State of Washington
DEPARTMENT OF FISH AND WILDLIFE

September 1, 2020

SUBJECT: WDFW COMMENTS ON SE-20-00003 BROWN & JACKSON

Thank you for the opportunity to comment on the proposed grading permit and SEPA for the Brown & Jackson Storage Ponds project near Parke Creek. The Washington Department of Fish and Wildlife (WDFW) is familiar with this area and nearby critical areas that should be considered as part of this review and determination process.

**BROWN & JACKSON**  
 Land Application Site  
 Preliminary  
 Site Map  
 Kittitas County  
 Washington

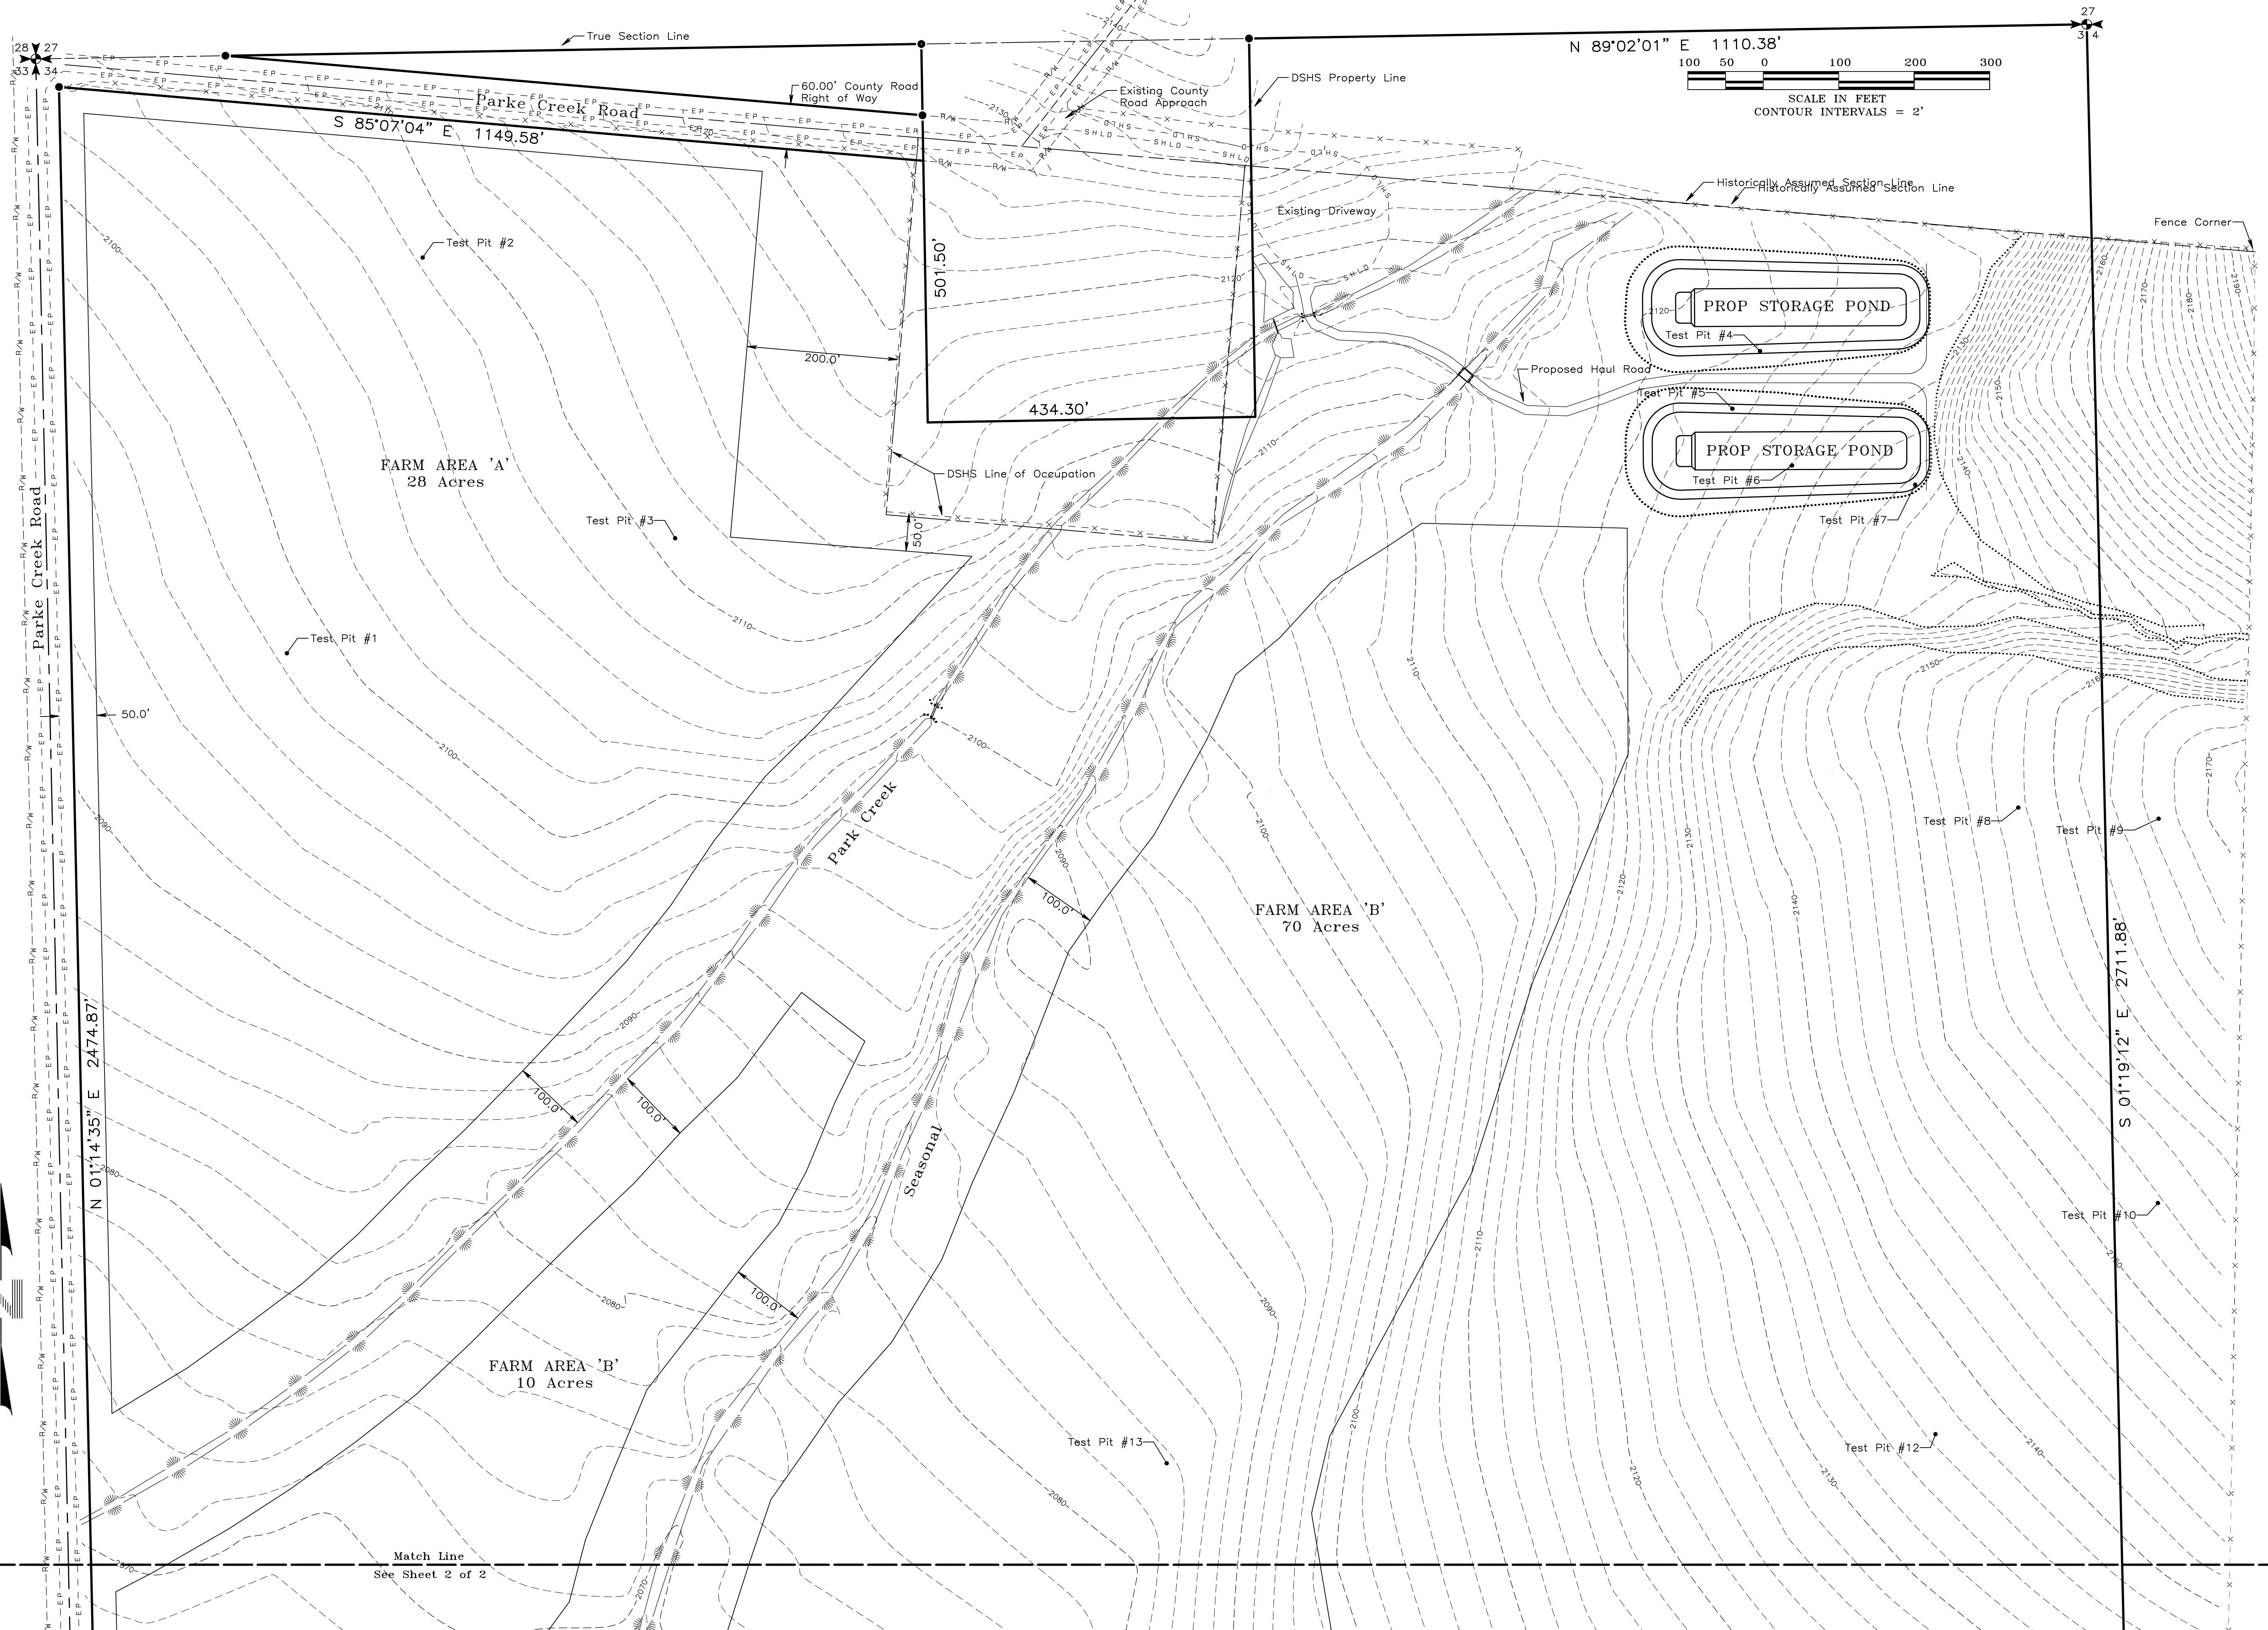
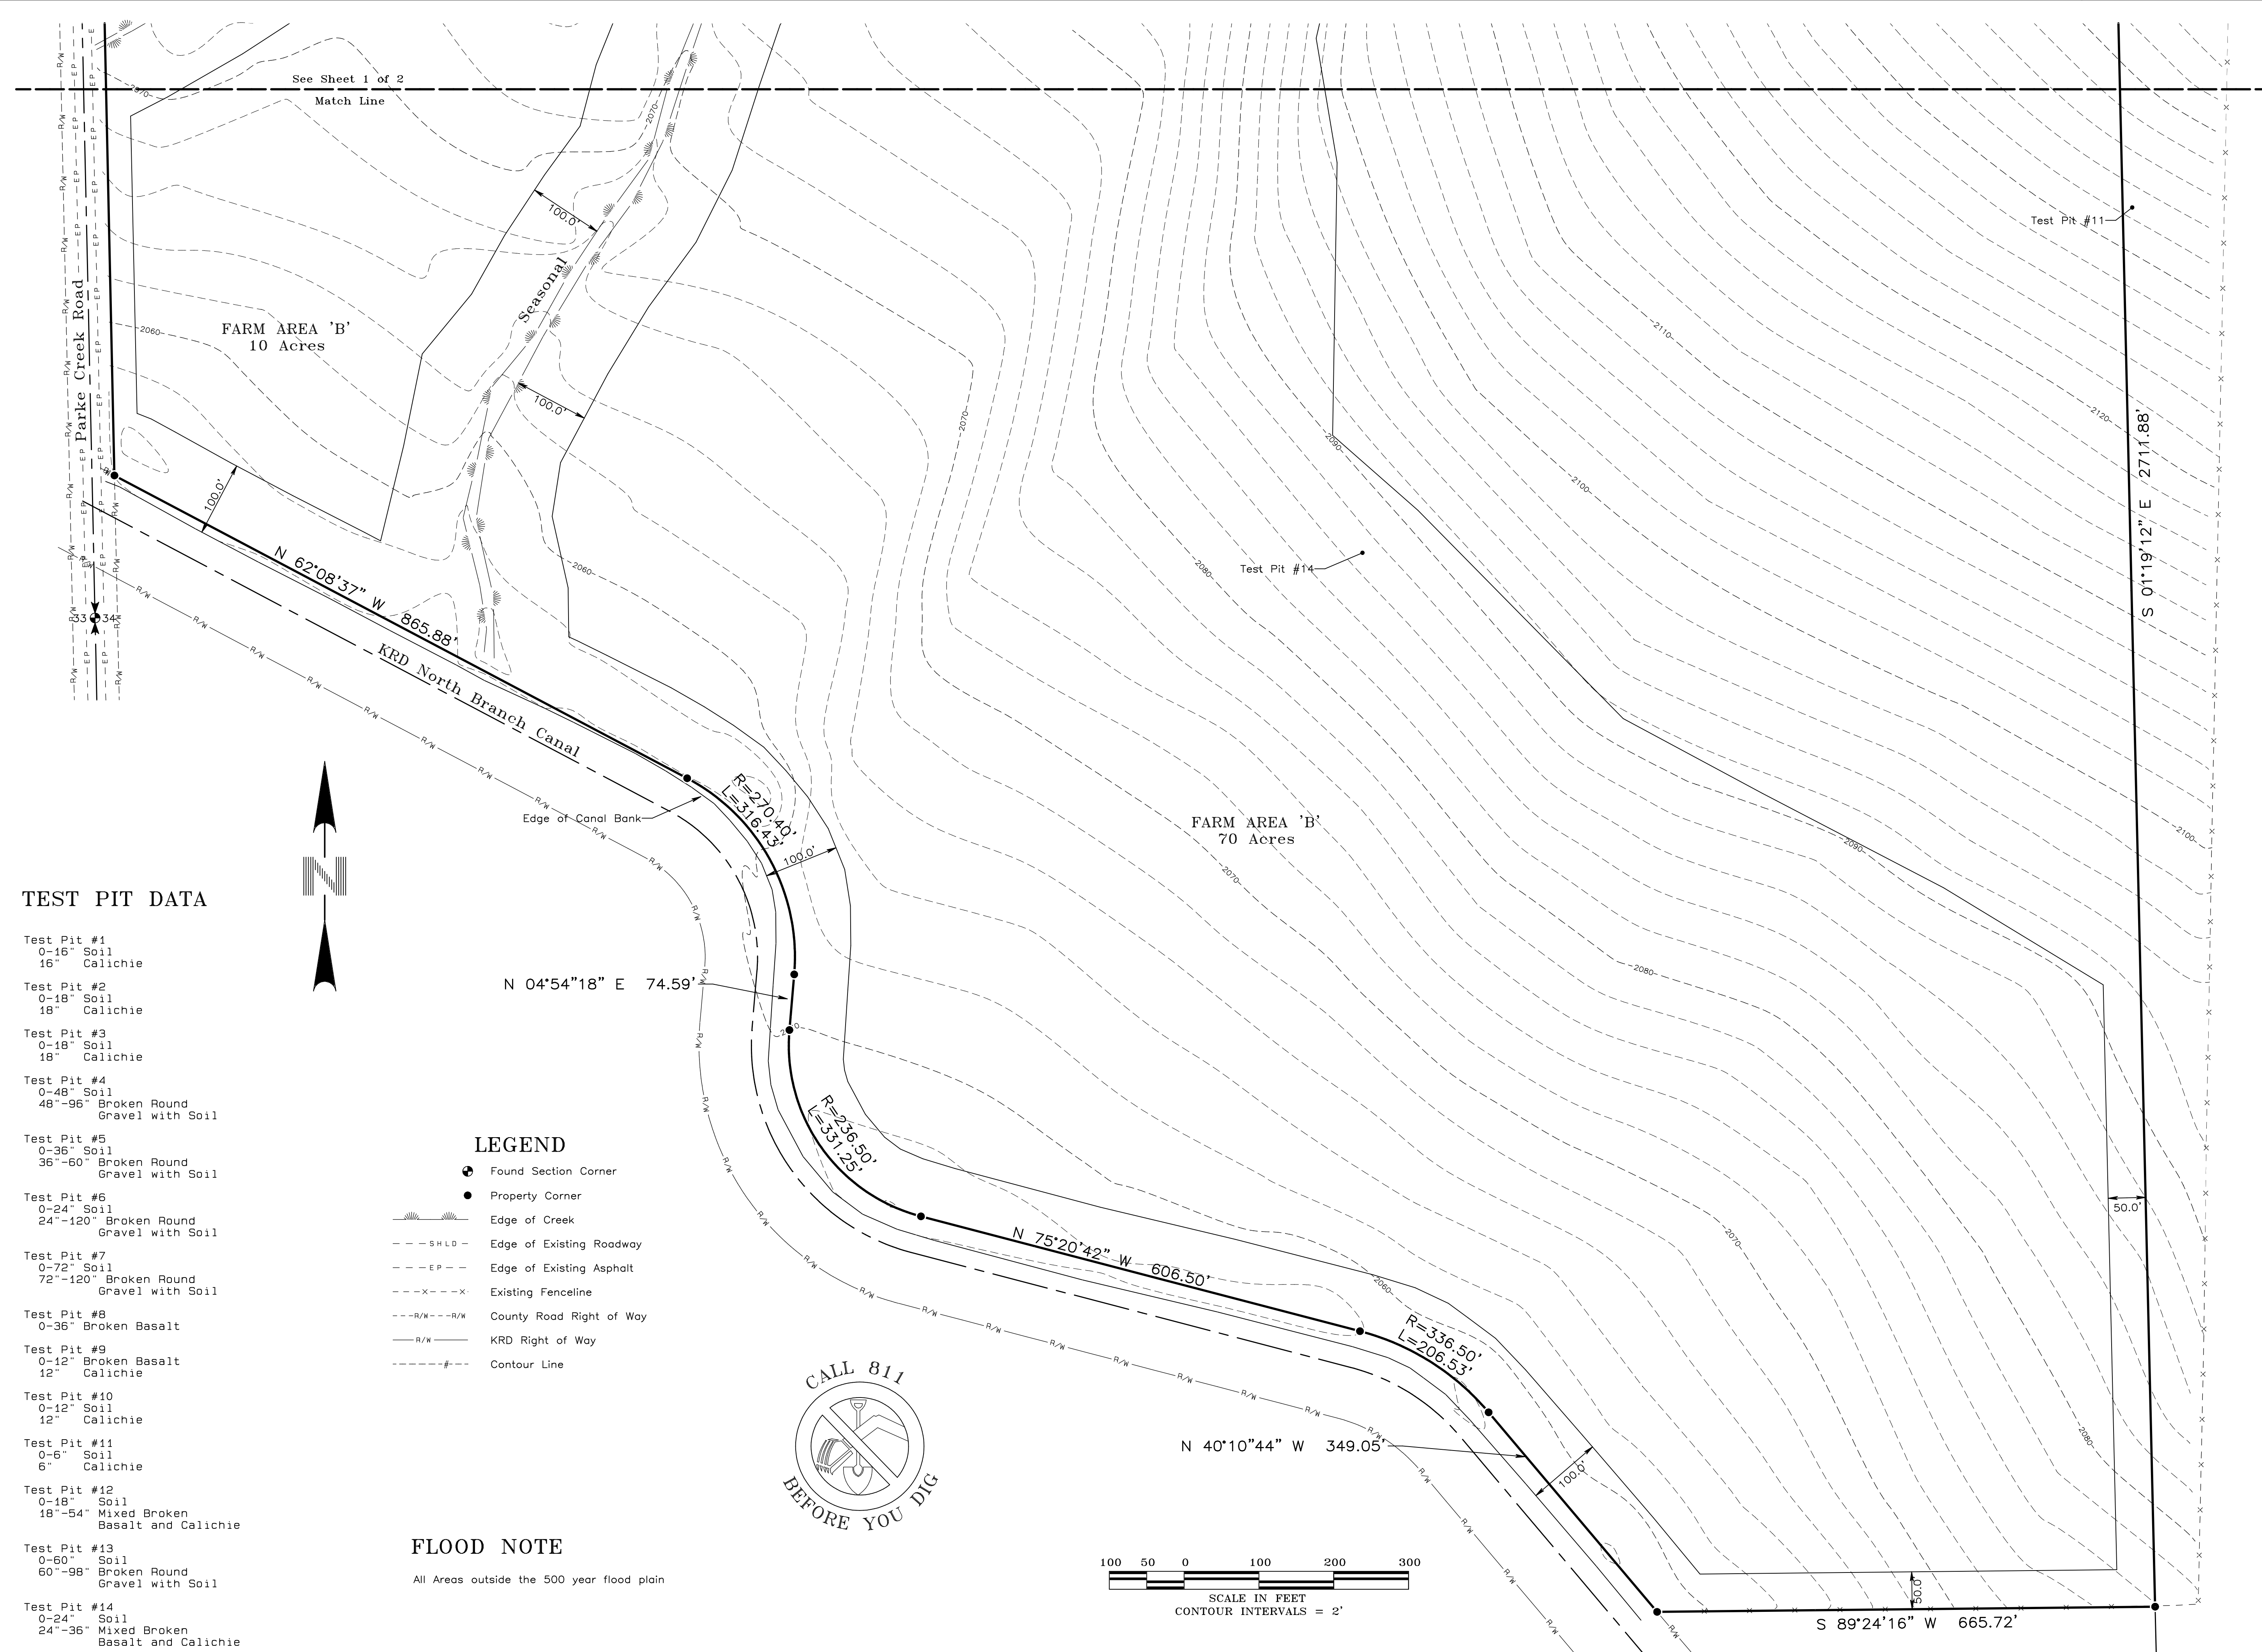
- The LIDAR available for this area and surveyed drawings submitted with the application clearly show three distinct streams within the parcel. The lidar imagery shows a meandering channel upstream of and through the project area and aerial photos show limited riparian habitat along the stream banks. Parke Creek is currently somewhat incised, but ice and/or debris jams during large storm or rain-on-snow events could result in out of bank flows through the parcel. The online USGS program, StreamStats, was used to calculate the estimated 100-year peak flood for this location. The model predicts

a 100-year flow of 1,160 cubic feet per second in Parke Creek. WDFW's online application for [Culverts and Climate Change](#) looks at ten different climate models to compare expected changes in hydrology. For this location in Parke Creek, all ten models agree that the 100-year flow will increase by the 2080s (Figure 2). The topography around the proposed septage storage ponds and Parke Creek does not seem to protect water quality in Parke Creek or the fish and wildlife associated with it if floodwaters were to overtake the storage ponds. **WDFW recommends that the applicant complete a full hydraulic and hydrologic report for WDFW's review prior to approval of the project to ensure there will be no impacts to the channel migration zone or frequently flooded areas of Parke Creek.**
